**Re: LHM Jeep Dodge  
Request for Permanent C.O. - Accepted  
Engineer's Stamp Date 3-31-16 (K19D023)  
Certification date: 2-10-17**

**RE: LHM Jeep  
Grading and Drainage Plan (Stamp Date 3-31-2016)  
Hydrology File: K19D023**

**Cc:** Cherne, Curtis; Harmon Rita T.  
**Subject:** LHM Jeep - K19D023 - Stamp Date 3-31-2016

Grading and Drainage Plan

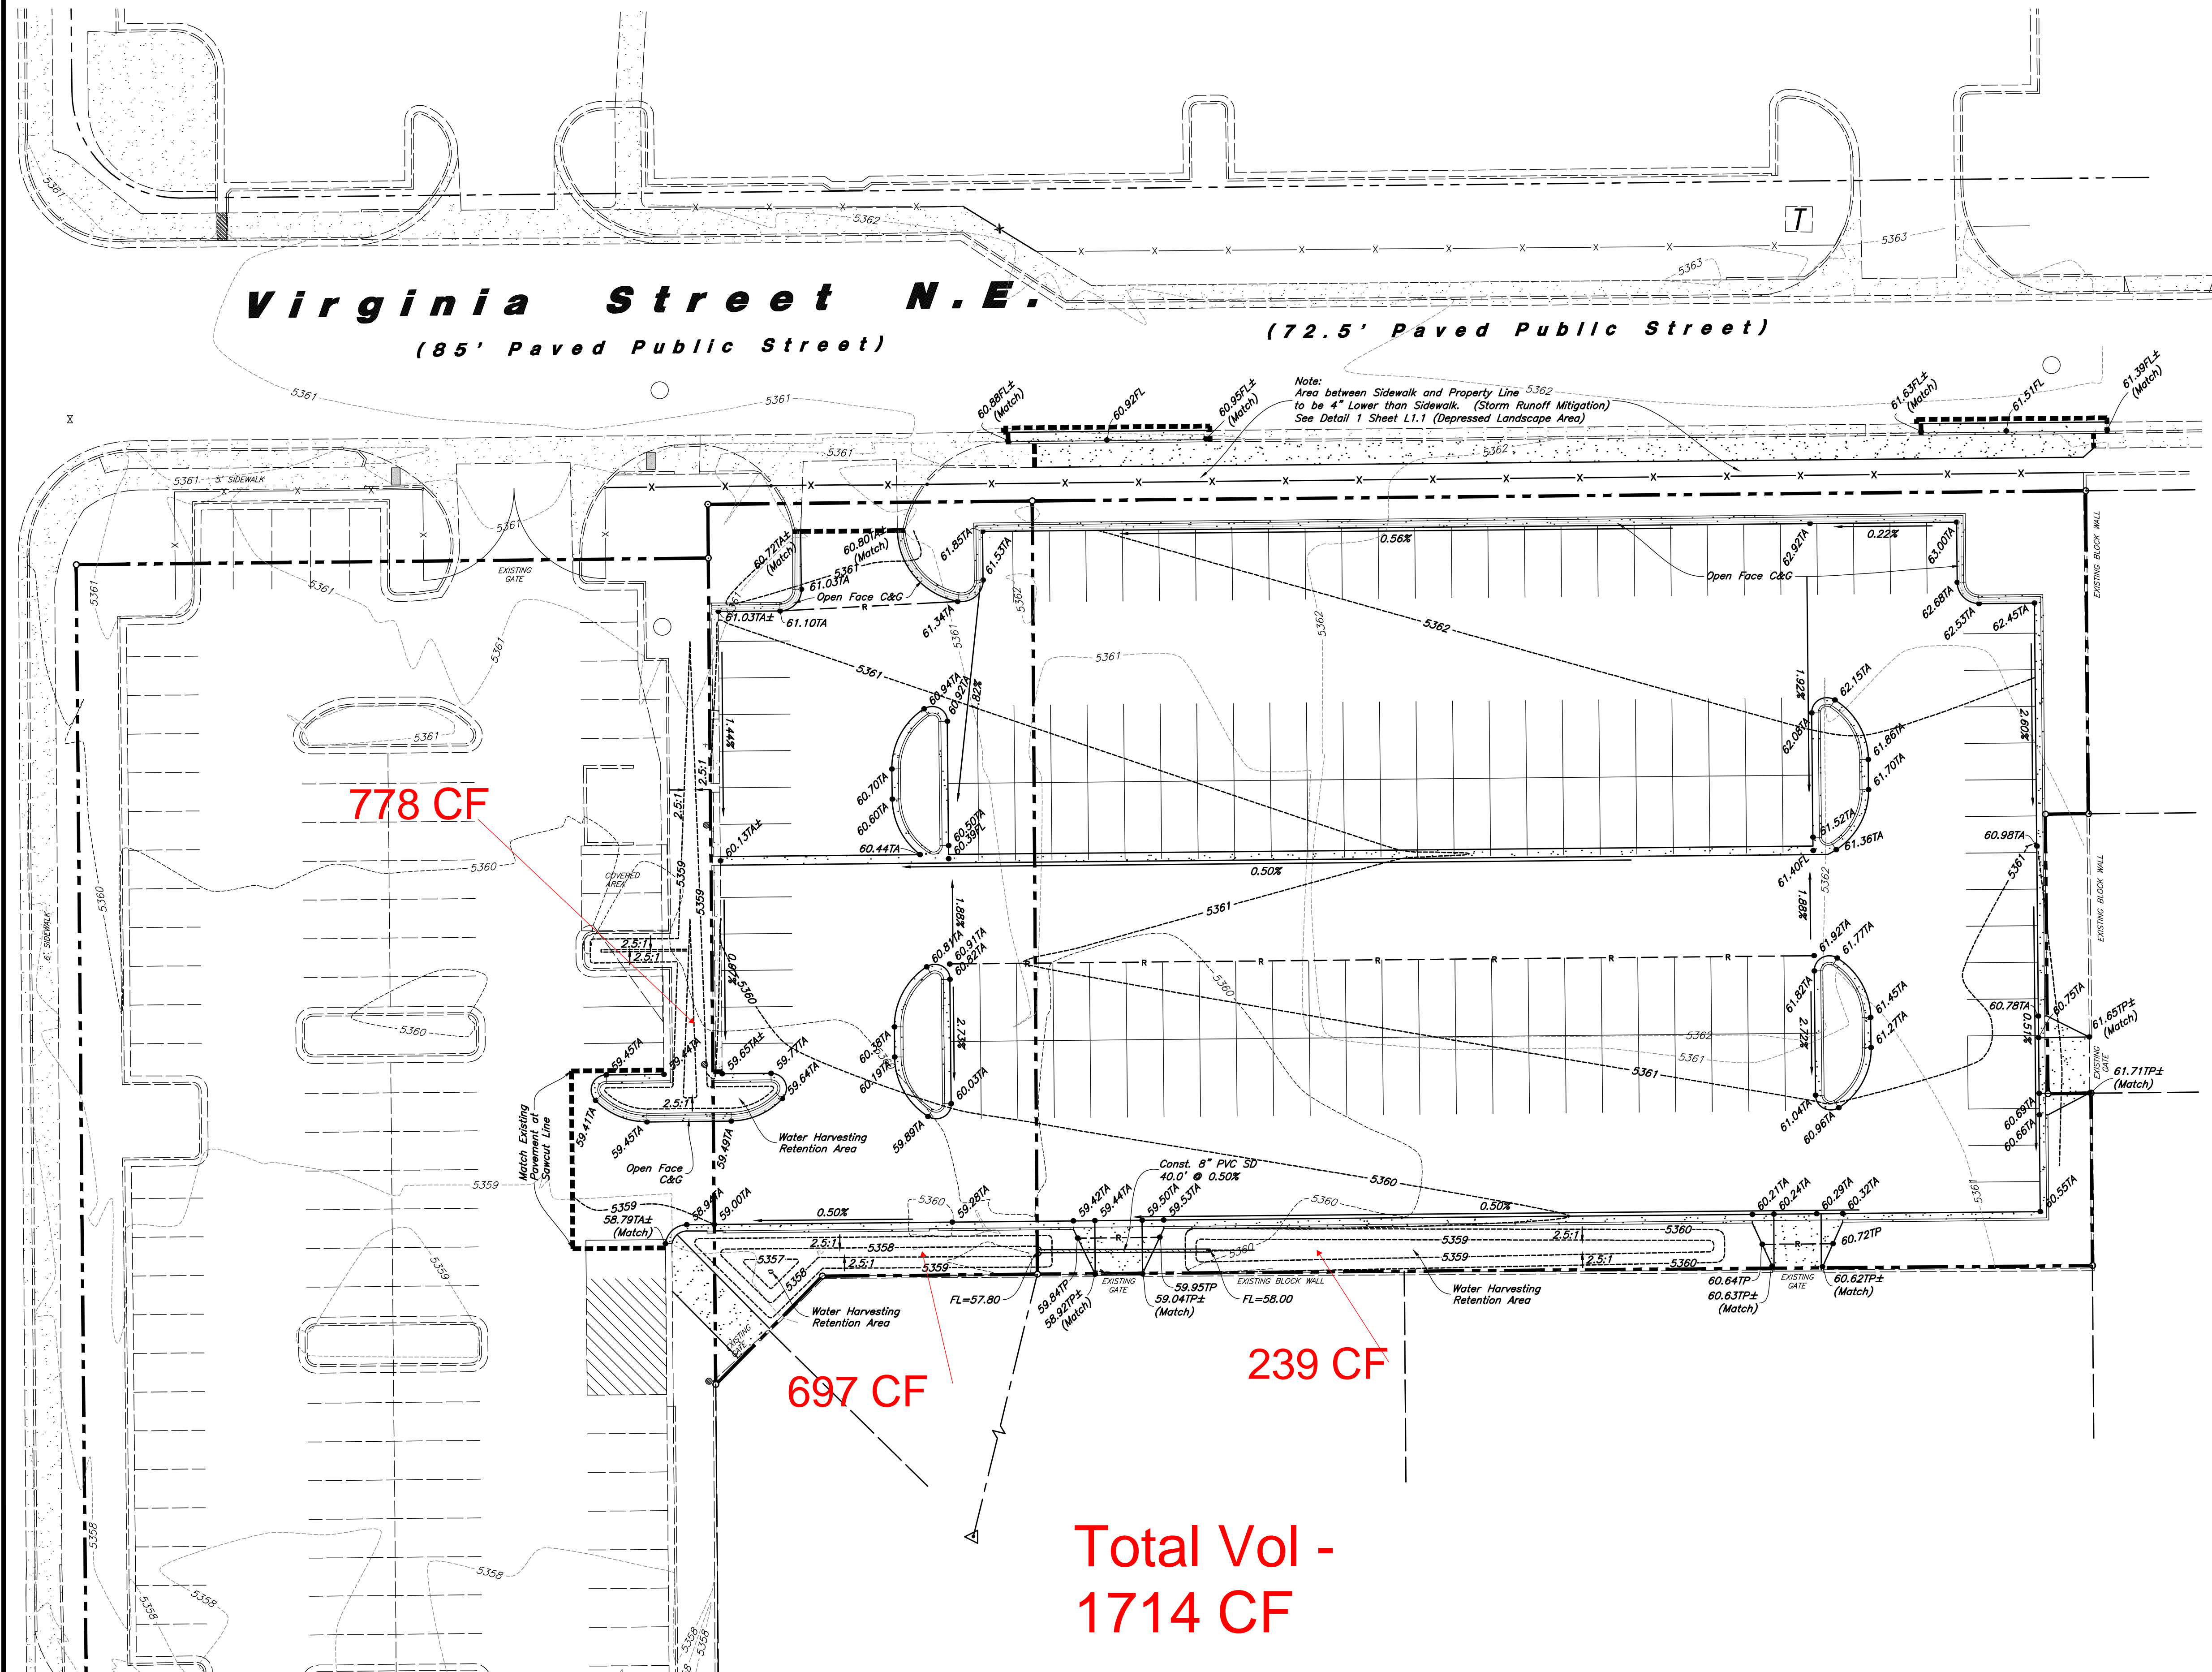
1. We agree with the concept of replacing the underground structure with surface management for first flush; it will be easier to manage and maintain. However, the total calculated required volume needs to be accounted for. I also left you a message regarding maximizing the volume provided. Per your follow up exhibit, the pond volume provided exceeds the required volume. Item resolved

- a. Provide a calculation on the plan of the total first flush volume provided, and call out the pond bottom of each ponding area (unless you provide a labeled contour). Provided in the exhibit

3. Call out the curb cut locations on the Grading Plan. They are shown on the site plan in the construction set.
4. For your information, evidence of the proposed lot consolidation will be required prior to approval for Certificate of Occupancy. Owner is working on the consolidation

RETENTION FOR FIRST FLUSH

1714 CF
